**Washington State
Department of Transportation**

Subject: CU-14-00004 McIntosh Small Scale Event Facility
US 97 milepost 138.89 right

We have reviewed the proposed project and have the following comments.

EXISTING
OUTDOOR ARENA

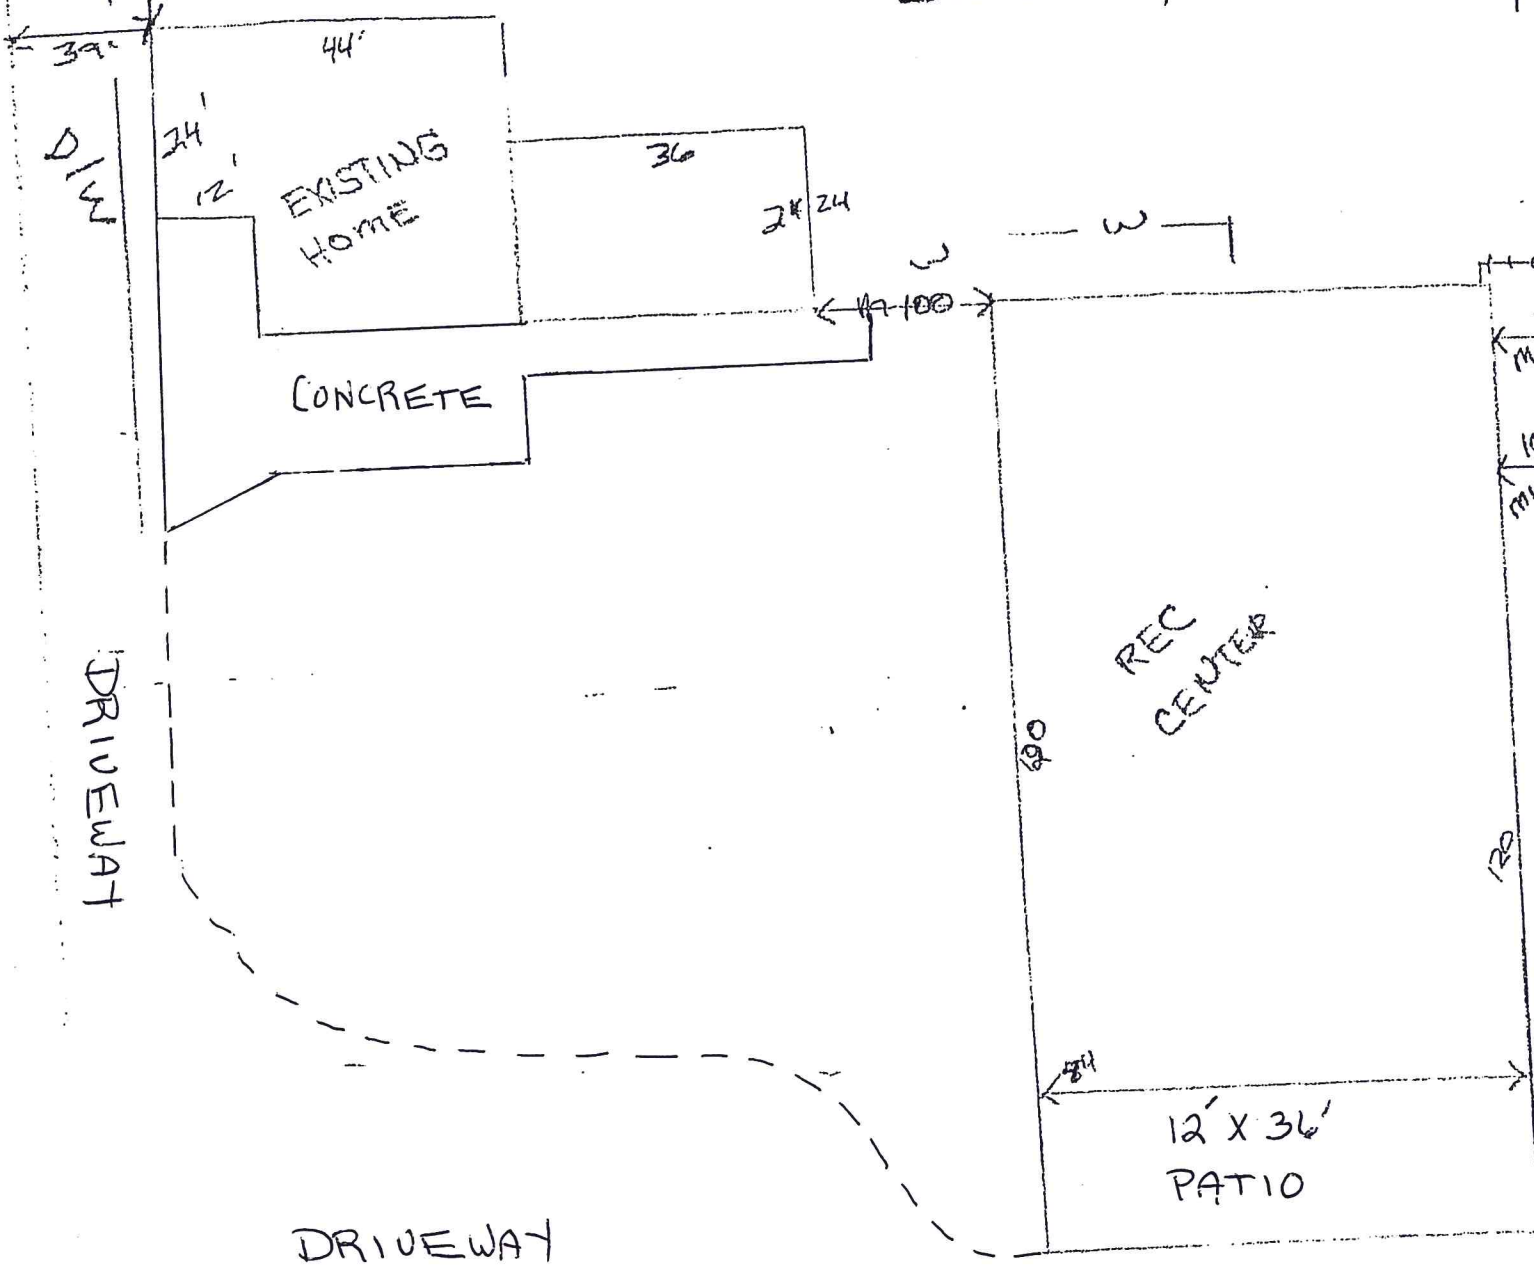
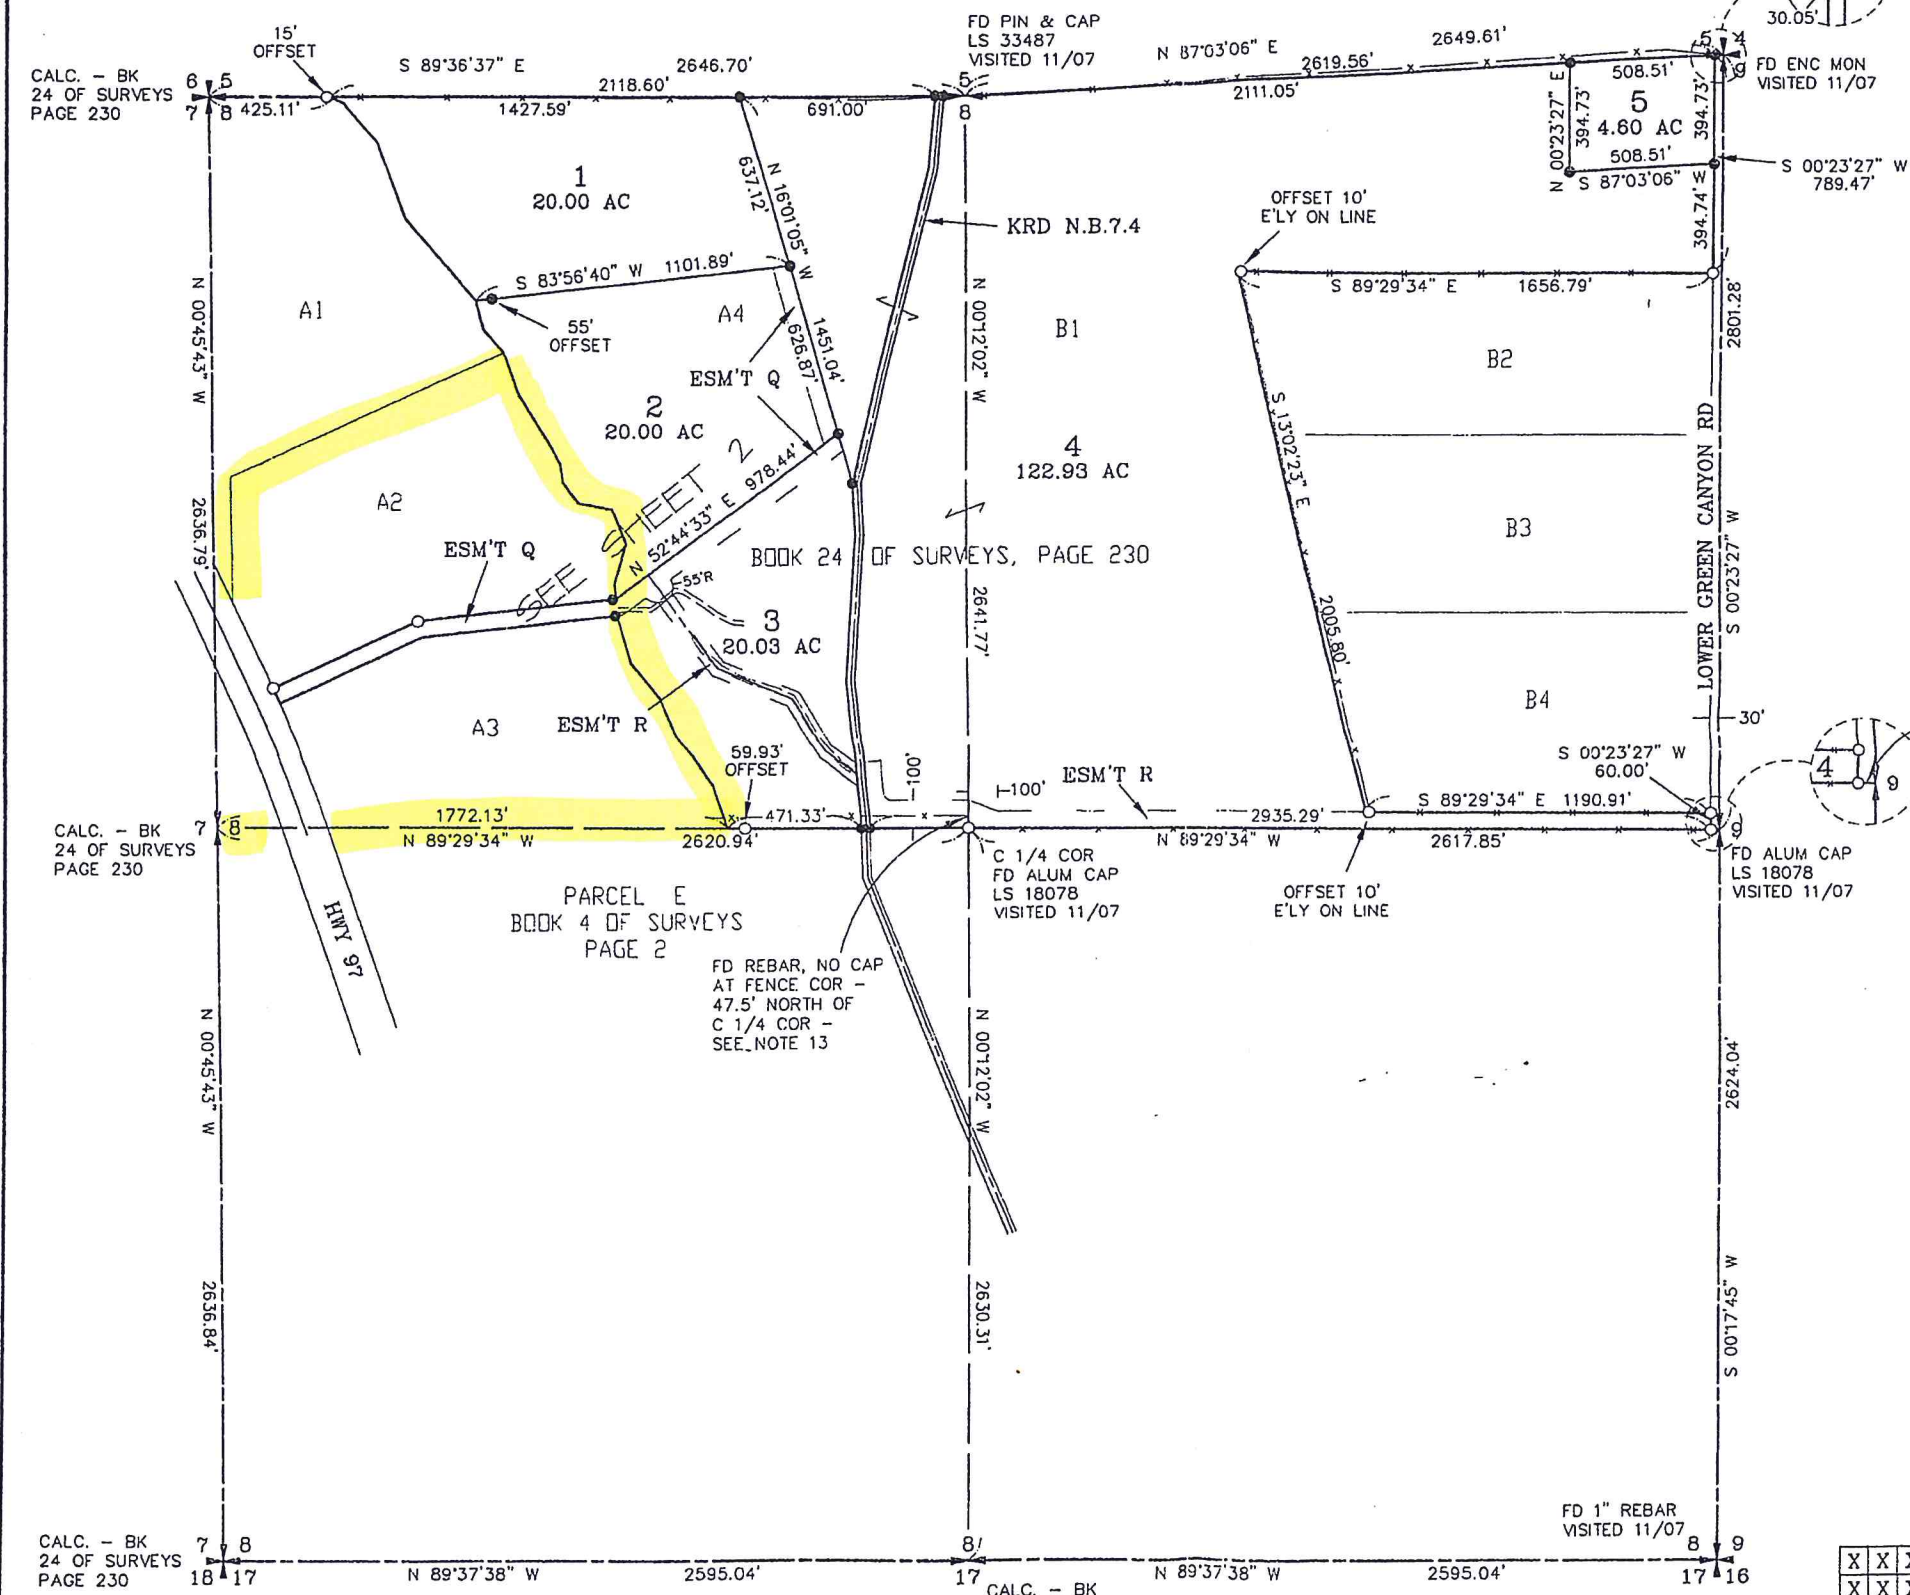
- The event facility is adjacent to State Highway 97 (US 97). US 97 is a Class 1 access managed highway with a posted speed limit of 65 miles per hour. The property has an existing permitted commercial approach at milepost 138.89 Right. The proponent has indicated that each event may generate 50-75 new trips. The proposed change in use for the subject property does not warrant further upgrades to the existing approach. However, the conditions of this approach permit allow up to 100 daily trips. If the number of daily trips crosses this threshold, as allowed within Kittitas County guidelines, the applicant is required to upgrade the permit to a Category II – Minor Connection. The fee for a Category II connection is \$1,000, which allows up to 1,000 daily trips. No new approaches to US 97 will be allowed. The property owner is required to contact Mark Kaiser at 509-577-1668 to update the permit if the threshold is exceeded.

- The County should require the proponent to provide obstruction-free ingress/egress for two-way traffic beyond the approach to prevent vehicles from backing up onto US 97 while entering the facilities during events. WSDOT highly encourages the County to require the use of on-site signage and parking attendants to manage the entering vehicles. If events cause vehicles to back up onto US 97, WSDOT will require the proponent to construct a right turn lane at the proponent's expense.

- Parking will not be permitted within WSDOT right-of-way. Appropriate on-site parking provisions are required during events. The decommissioned roadbed lying parallel to US 97 on the east side of the highway is within WSDOT right-of-way.

- Any outdoor signing proposed as part of this project must be placed on the subject property and not within WSDOT right-of-way.
